Your Ref 23/01151/APP

6th November 2023

PROPOSED NON-MATERIAL AMENDMENT TO PLANNING PERMISSION REF. 23/01151/APP AT HMP SPRINGHILL, EDGOTT, AYLESBURY

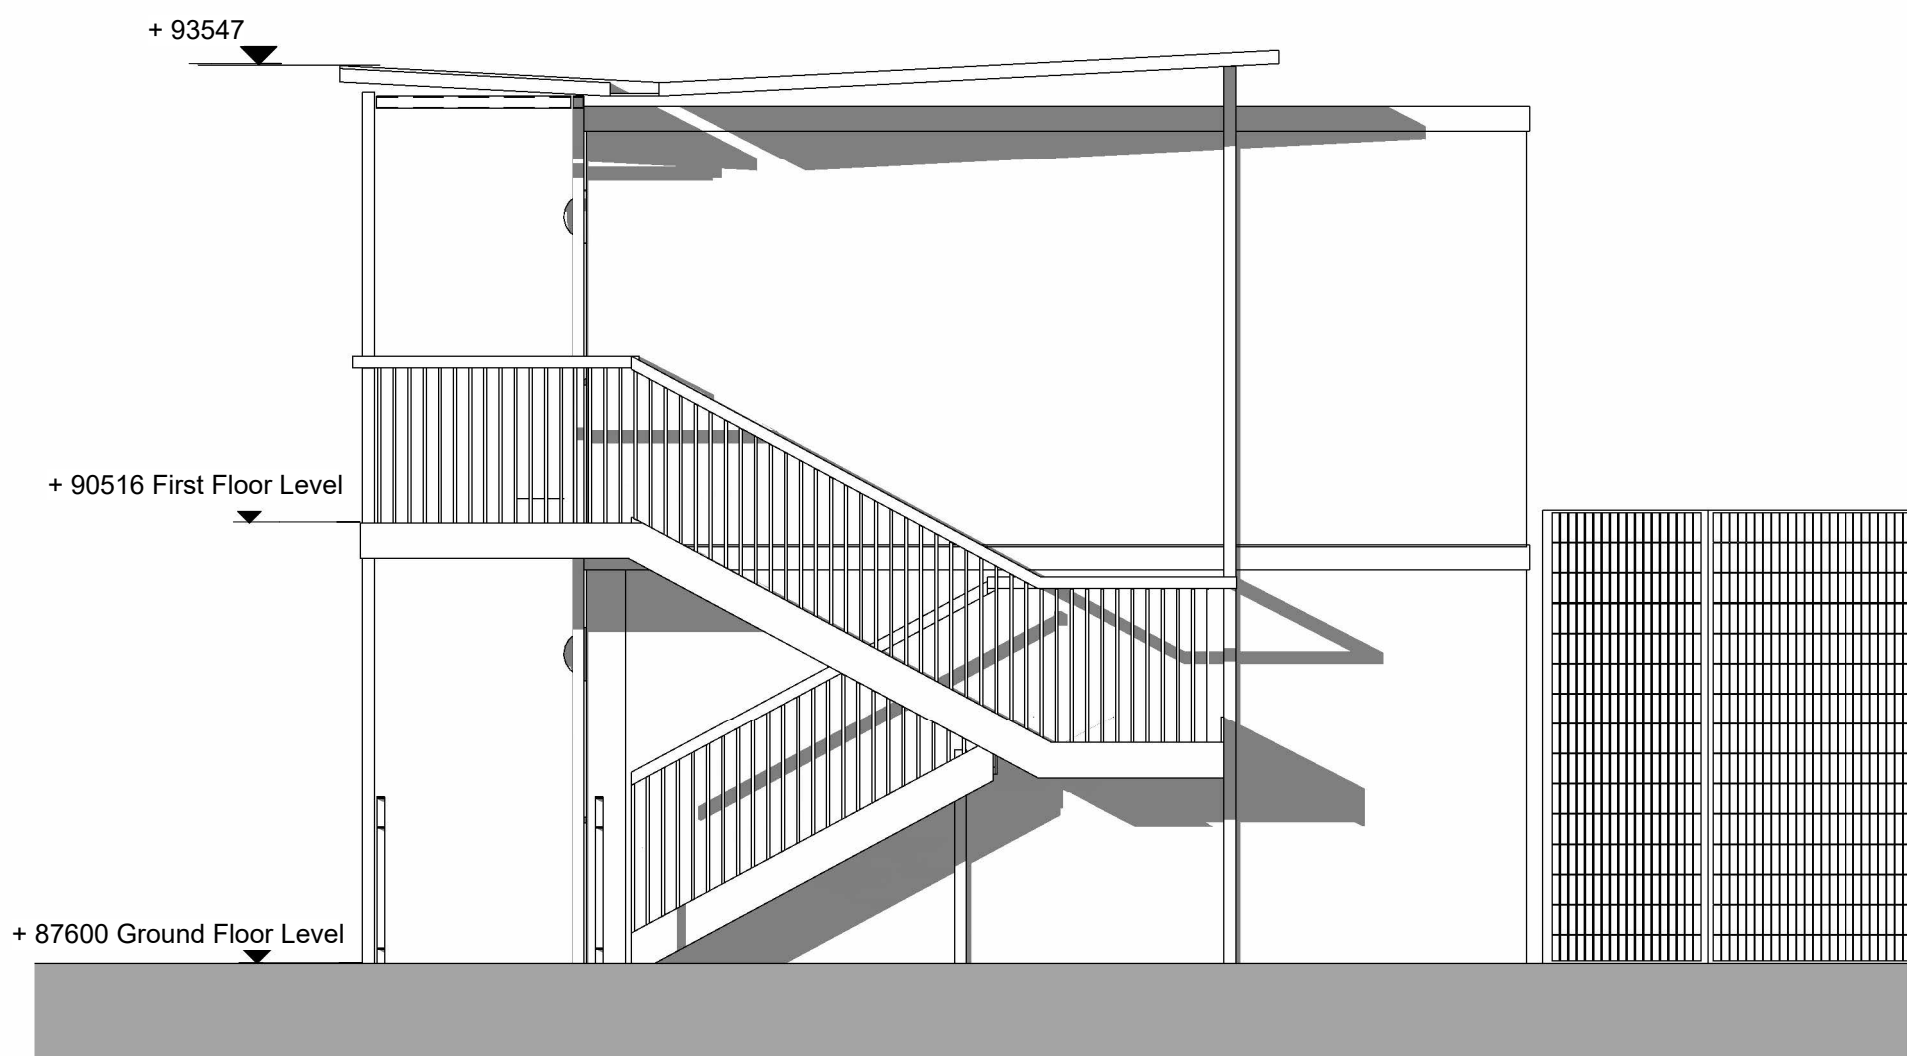
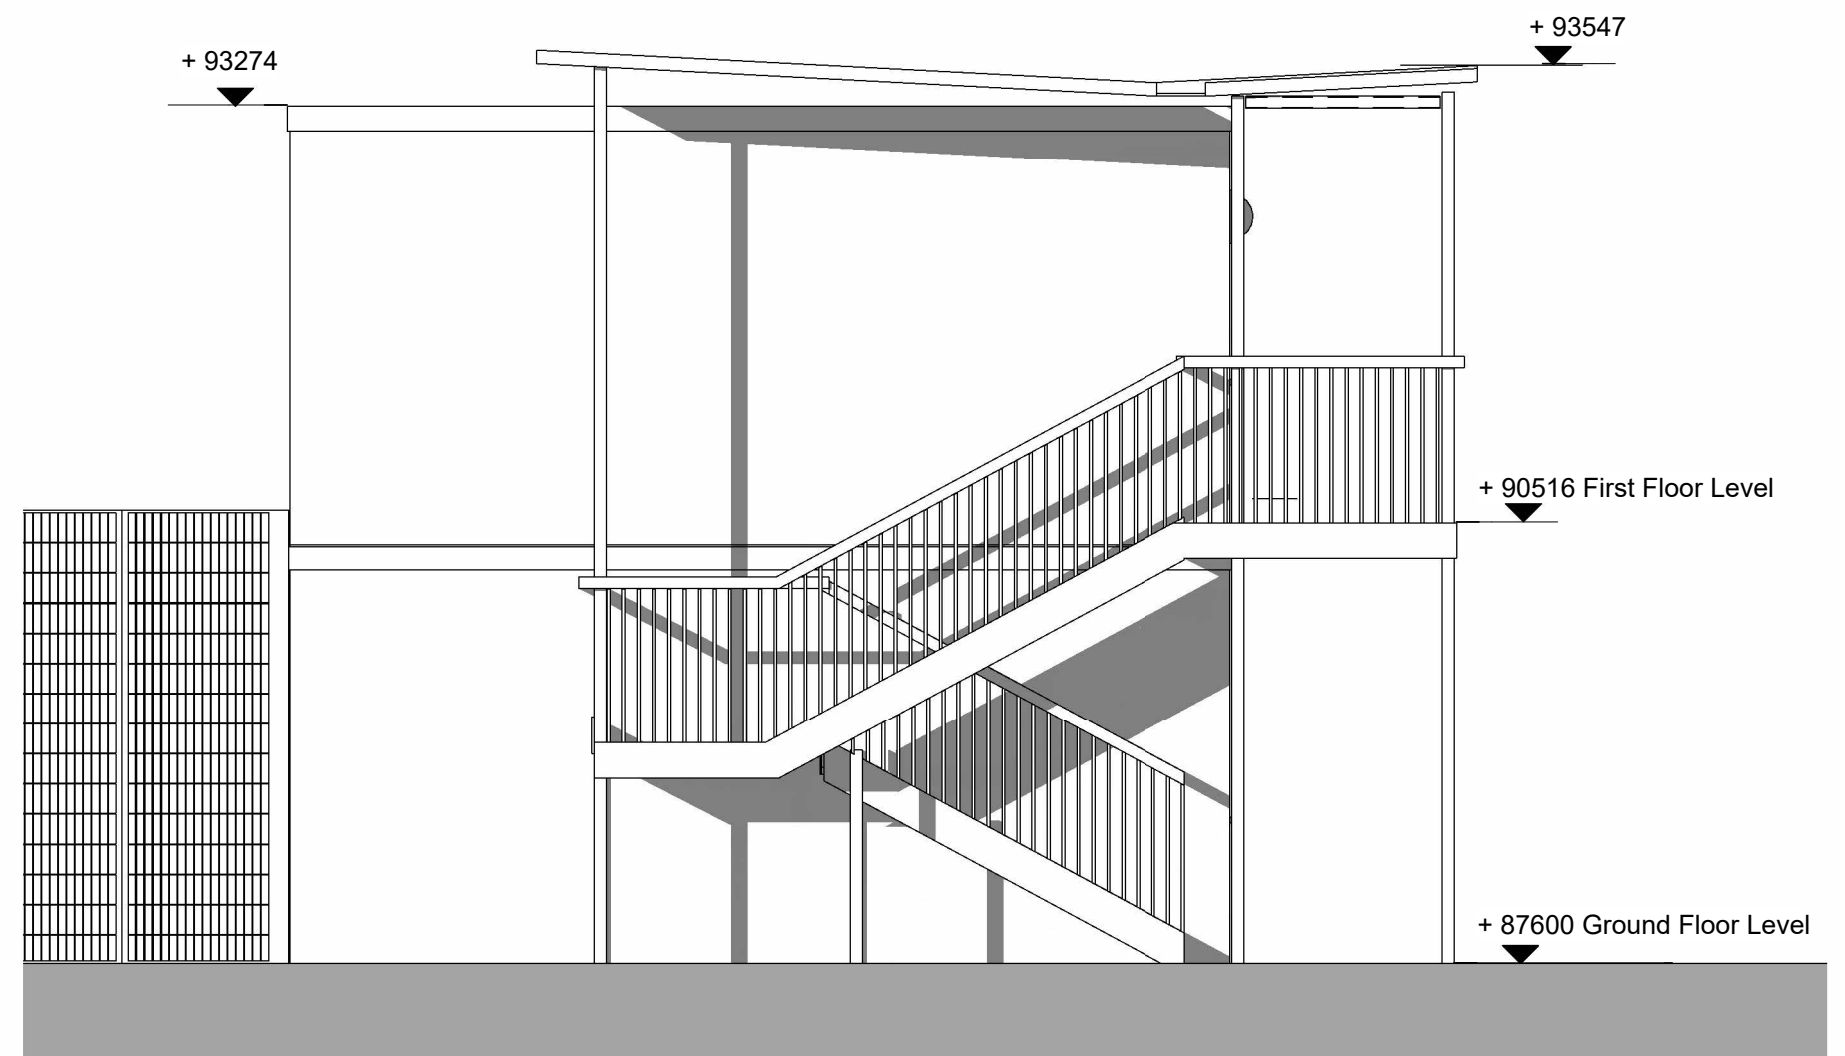
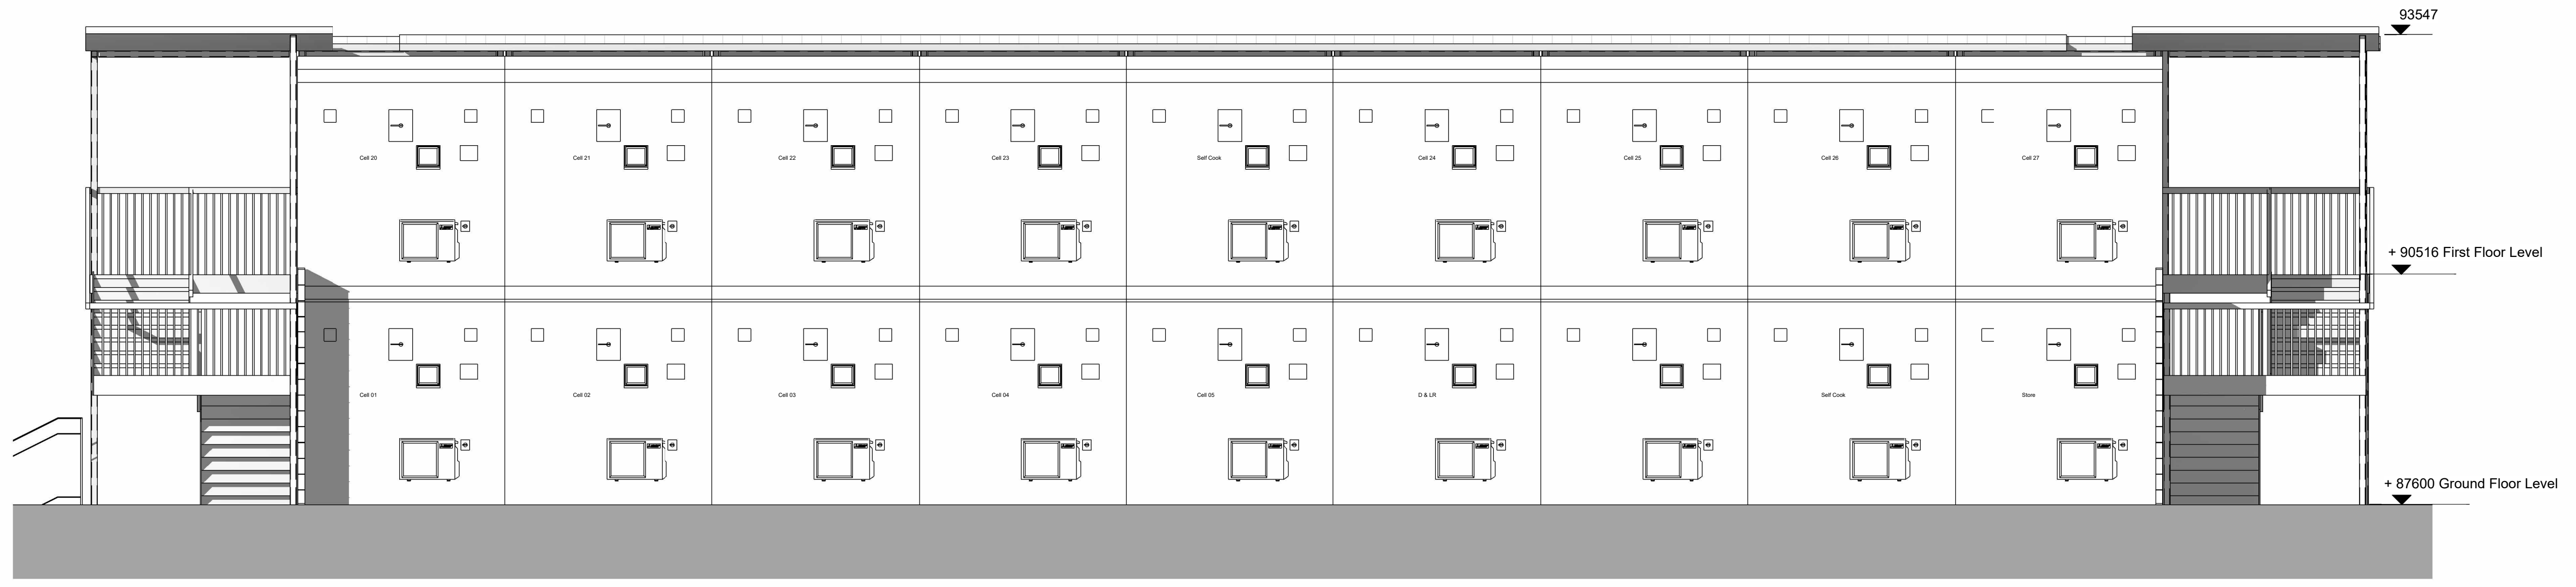
The finished floor levels of blocks 1 & 2 have been raised meaning the ridge is higher in comparison to the original. A step in the level has been removed as a result.

Change in appearance of the railings to the walkways (originally perforated sheets, now vertical slats).

Block 1 Proposed Elevations – Rev C (ref: 441830-HLN-ZZ-DR-A-P008)

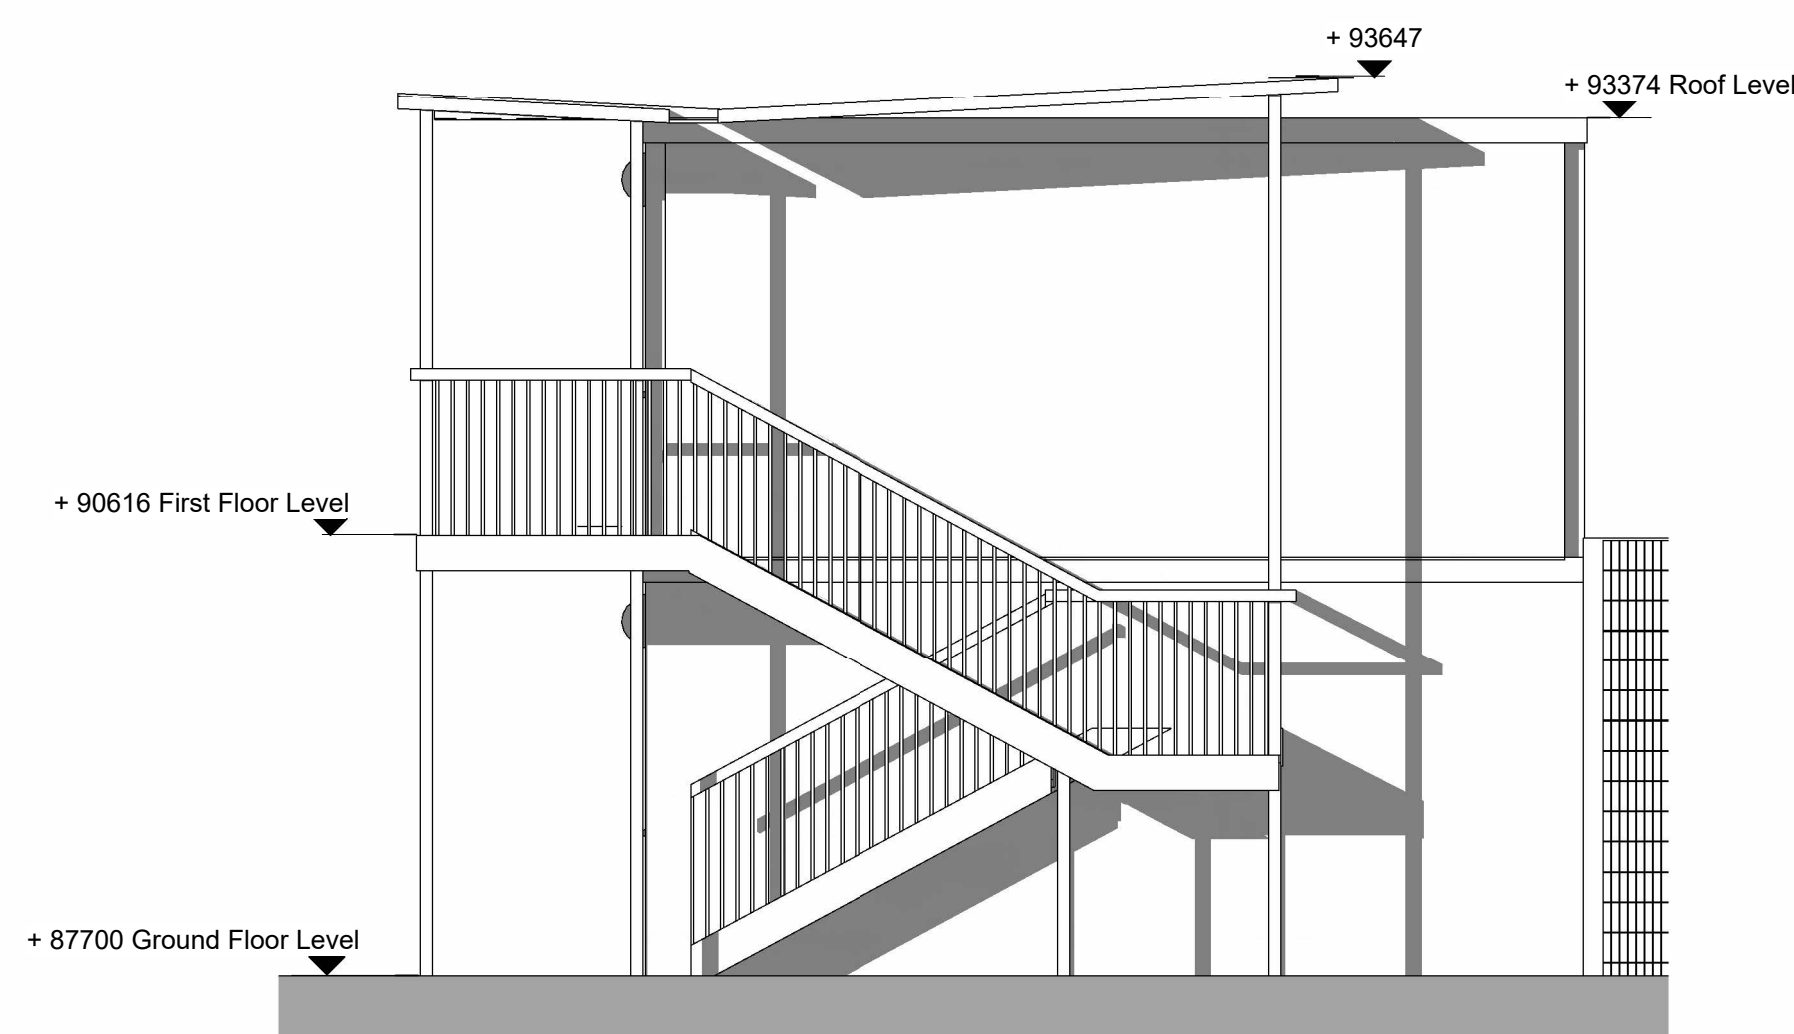
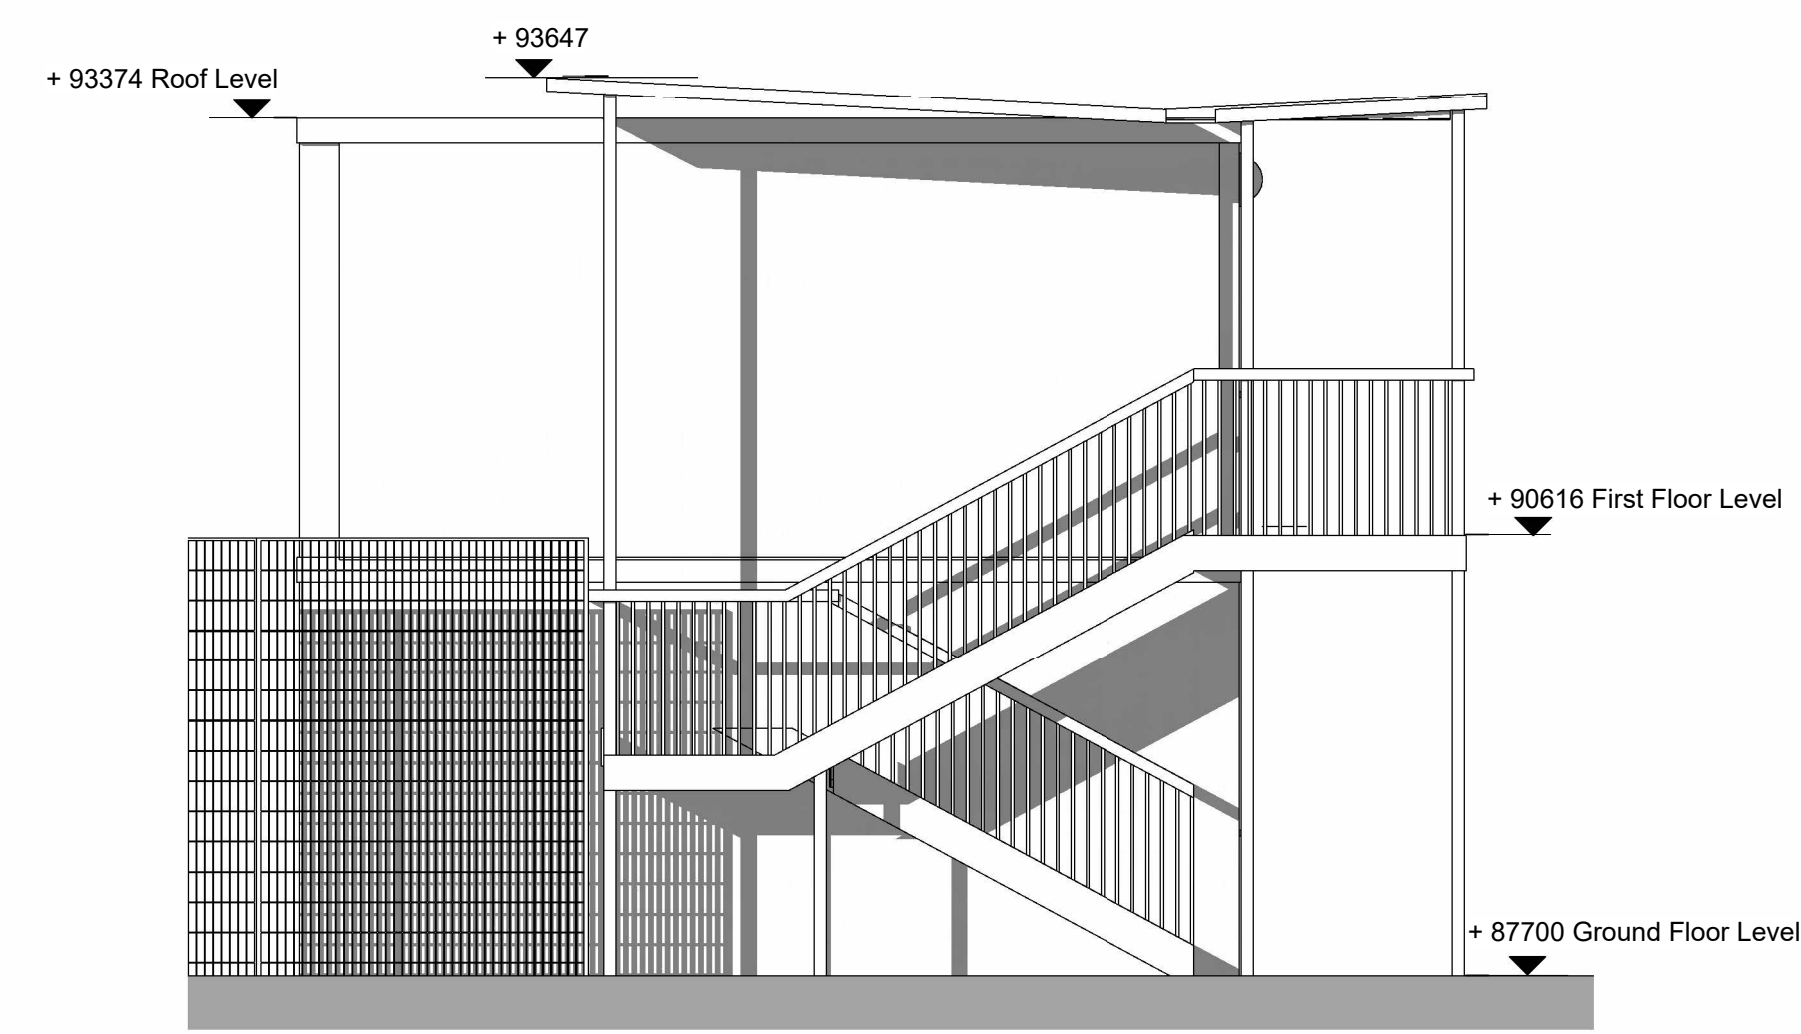
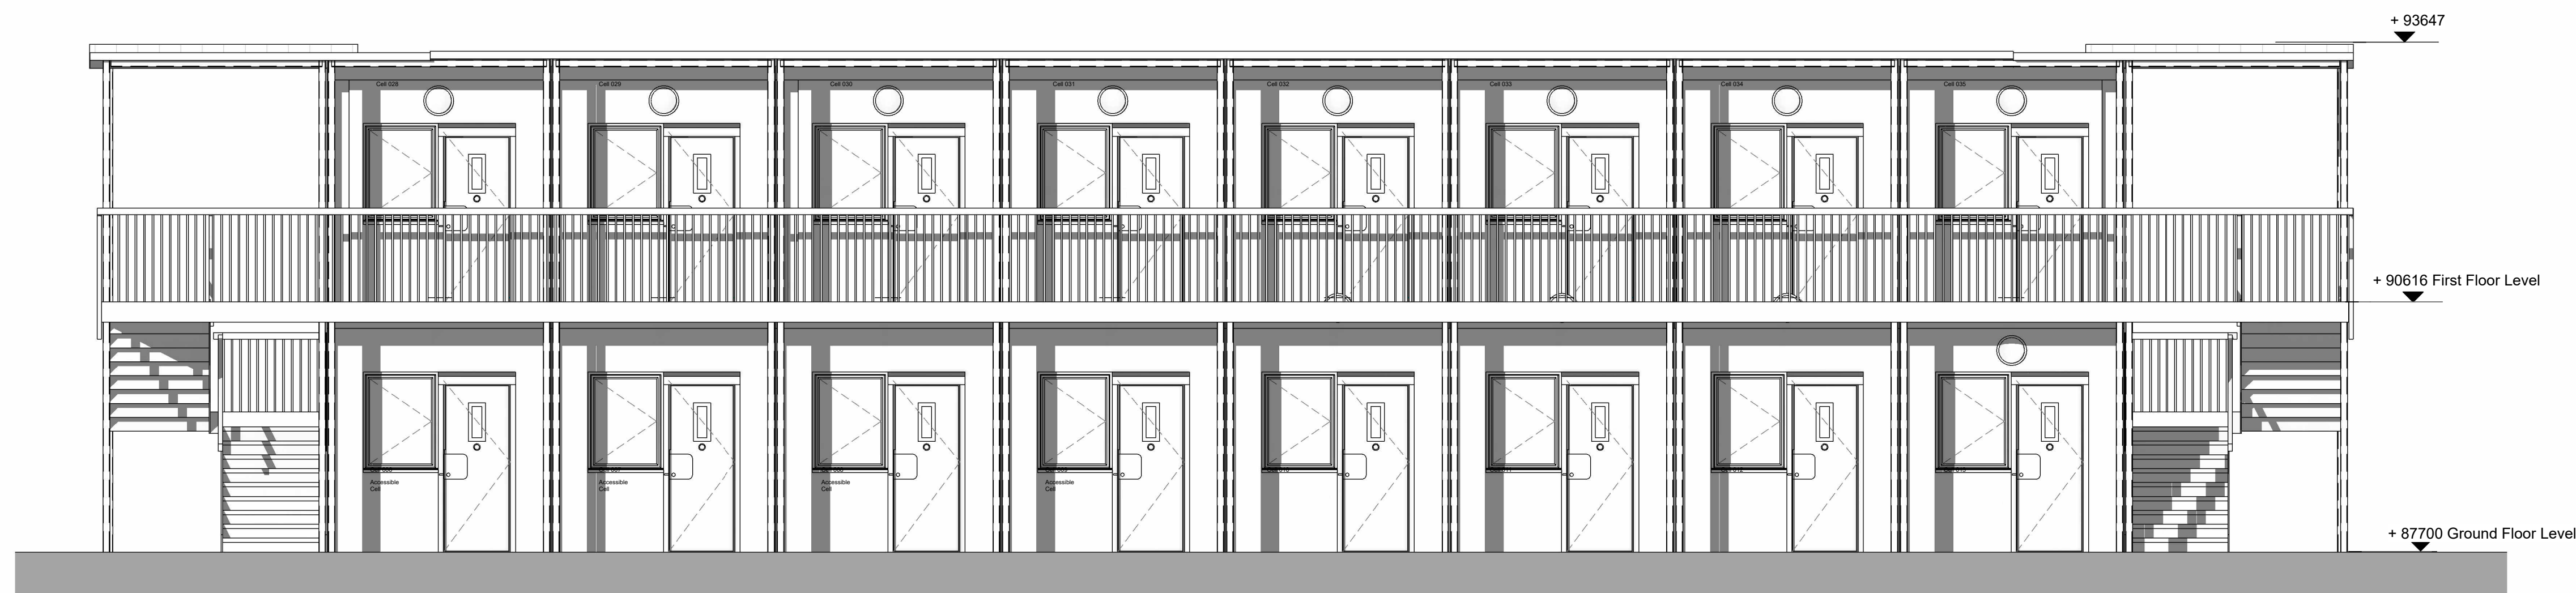
Block 2 Proposed Elevations – Rev C (ref: 441830-HLN-ZZ-DR-A-P009)

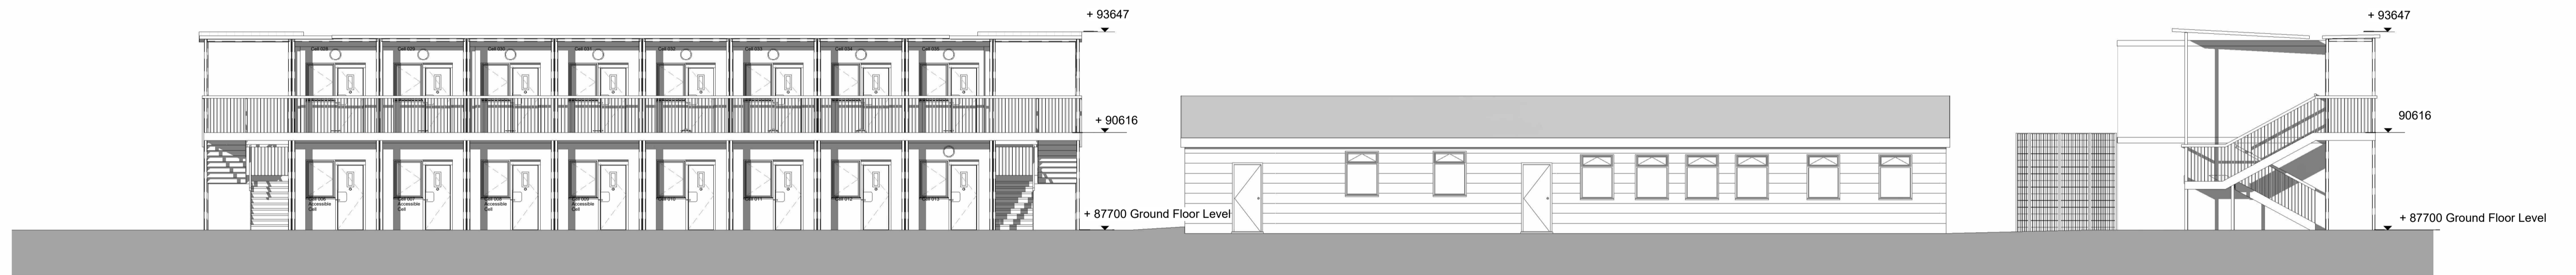
Existing and Proposed Street Elevation – Rev C (ref: 441830-HLN-ZZ-DR-A-P013)
